Our Case Number: ABP-317121-23

Re: BusConnects Swords to City Centre Bus Corridor Scheme
Swords to Dublin City Centre

Dublin Cycling Campaign

Re: Bus Connects Dublin - Swords to City Centre: Case HA06D.317121

Drawing Title: **SWORDS TO CITY CENTRE CORE BUS CORRIDOR SCHEME JUNCTION SYSTEM DESIGN SWORDS ROAD / TURNAPIN LANE JUNCTION**

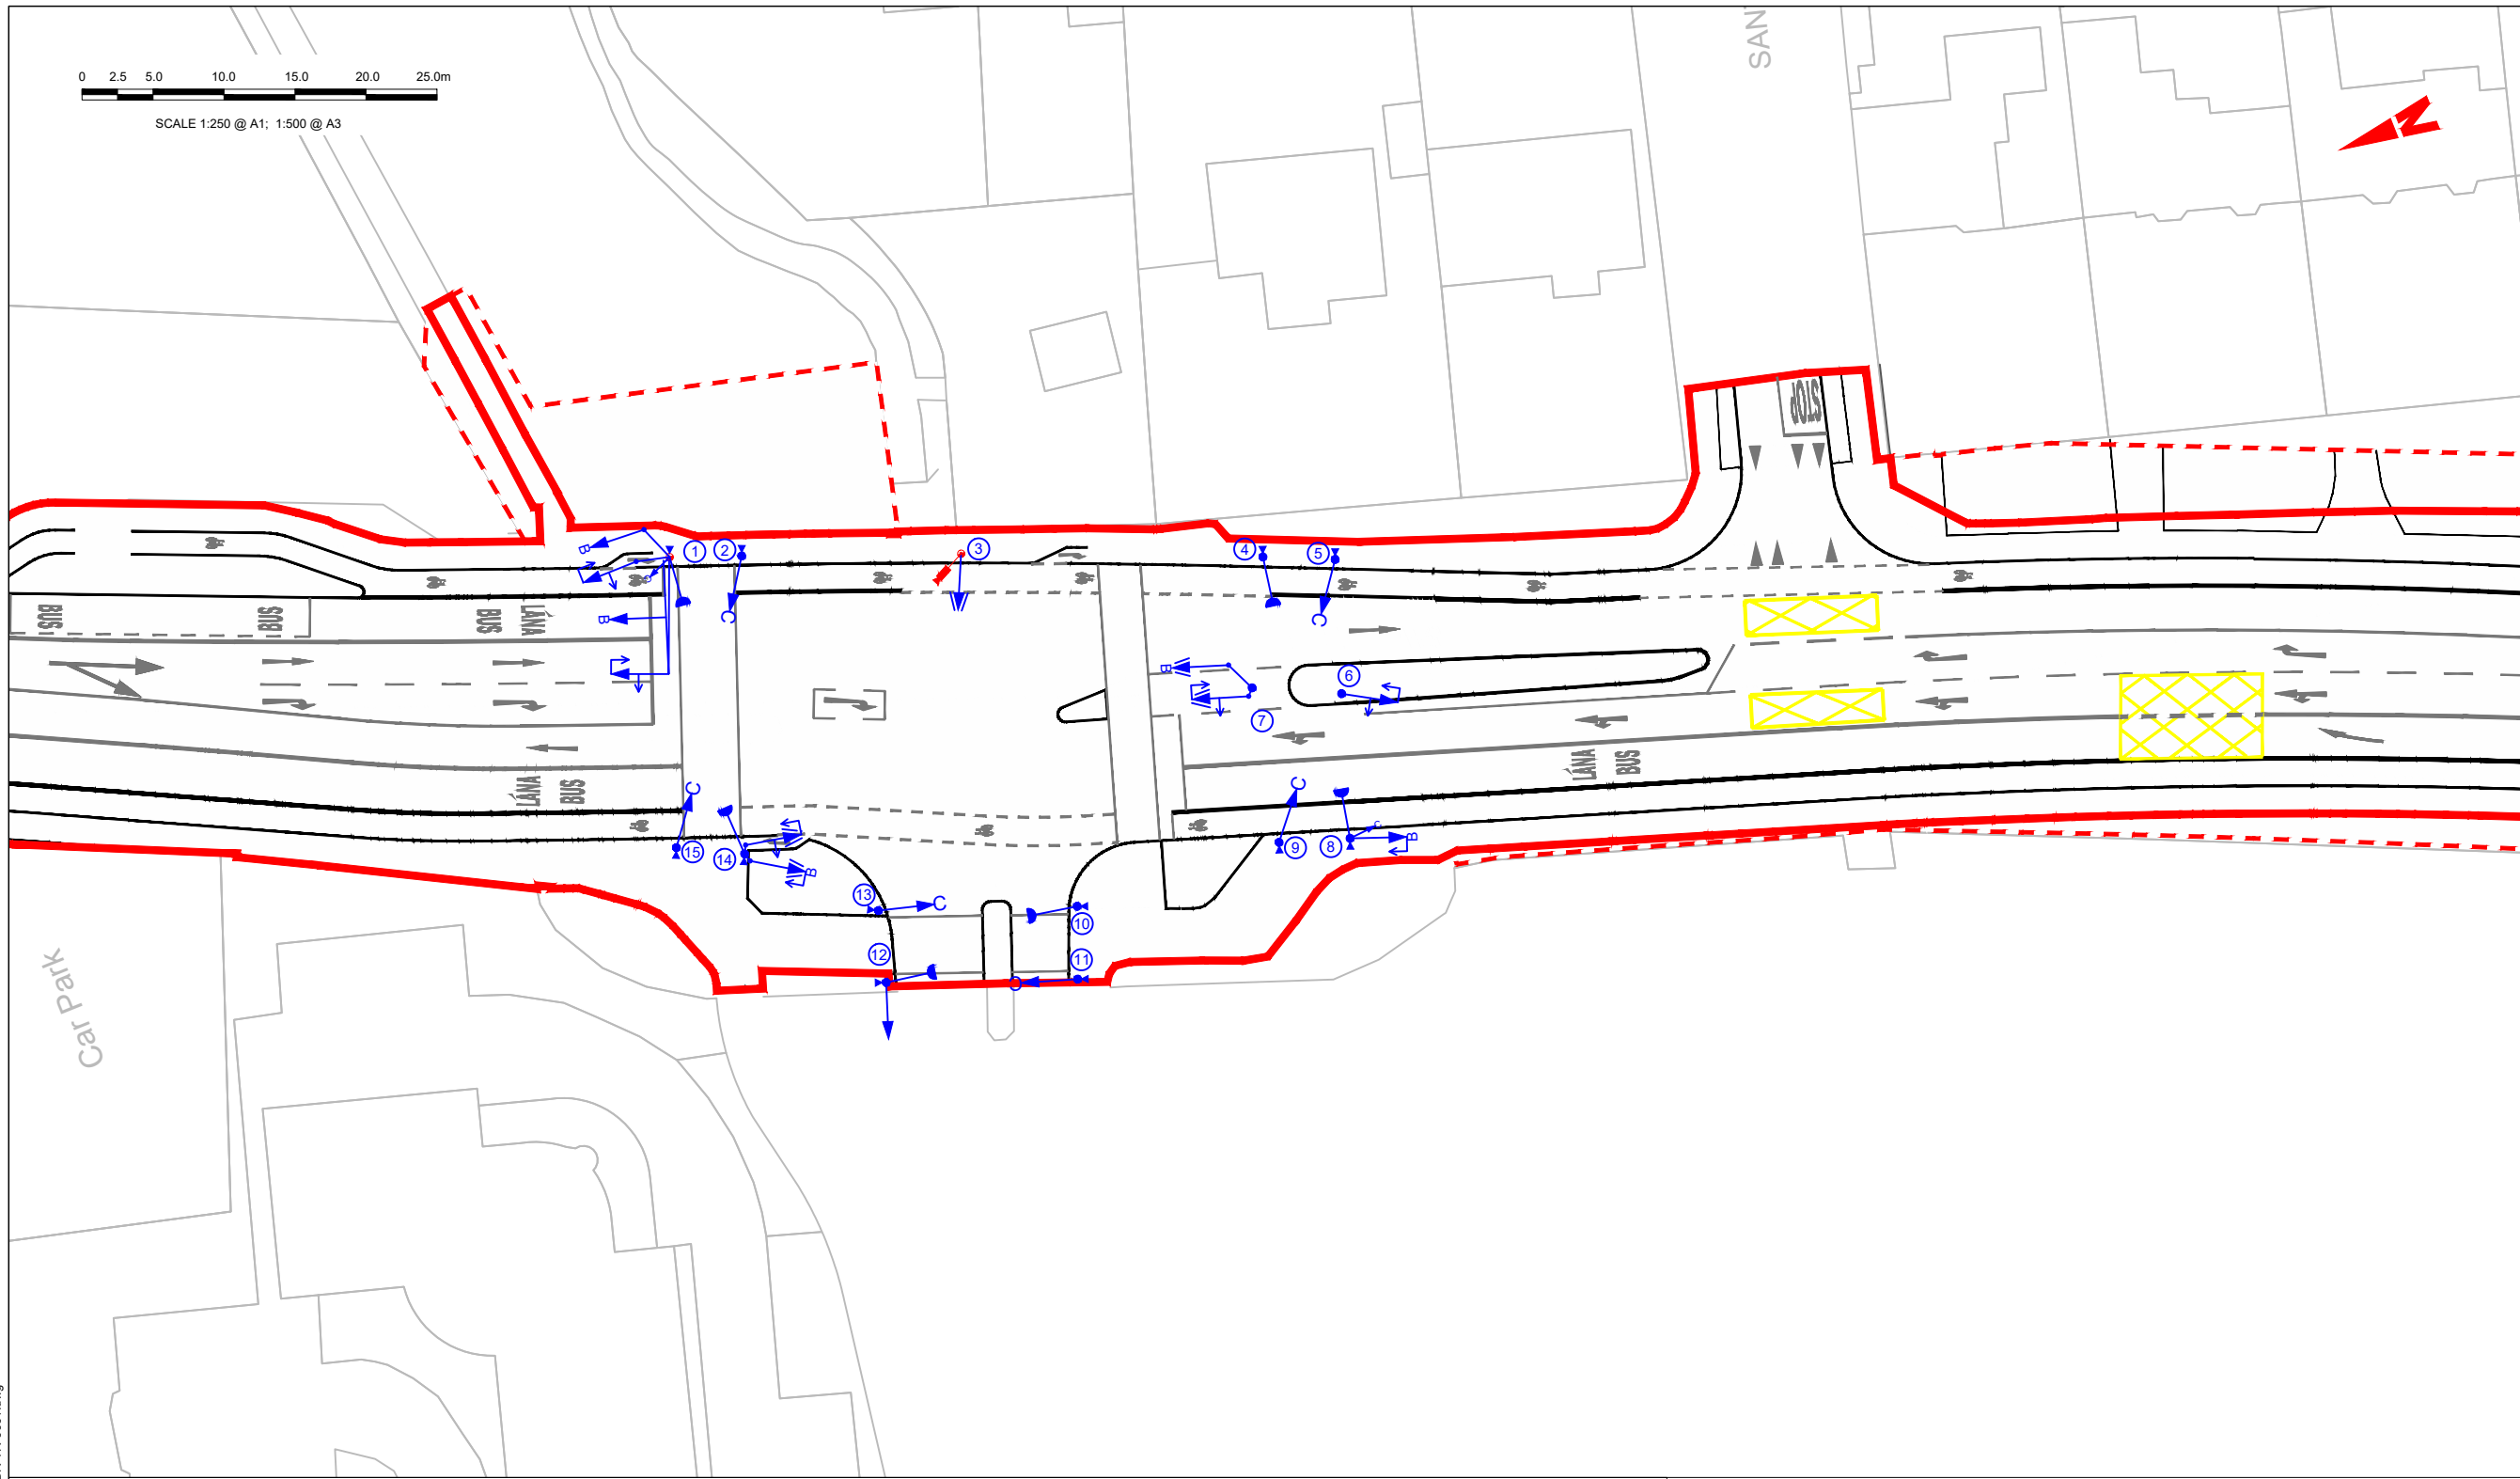
- Northwood Avenue Junction advises cyclists to use Toucan Crossings to navigate entering or leaving the Main Swords Road despite this being contra to the clear advice of the new Cycle Design Manual (CDM) as outlined in Section 4.4.4.3 - *'As shared facilities are generally disliked by both pedestrians and cyclists, signal controlled junctions with toucan crossings should only be used in exceptionally constrained environments'*
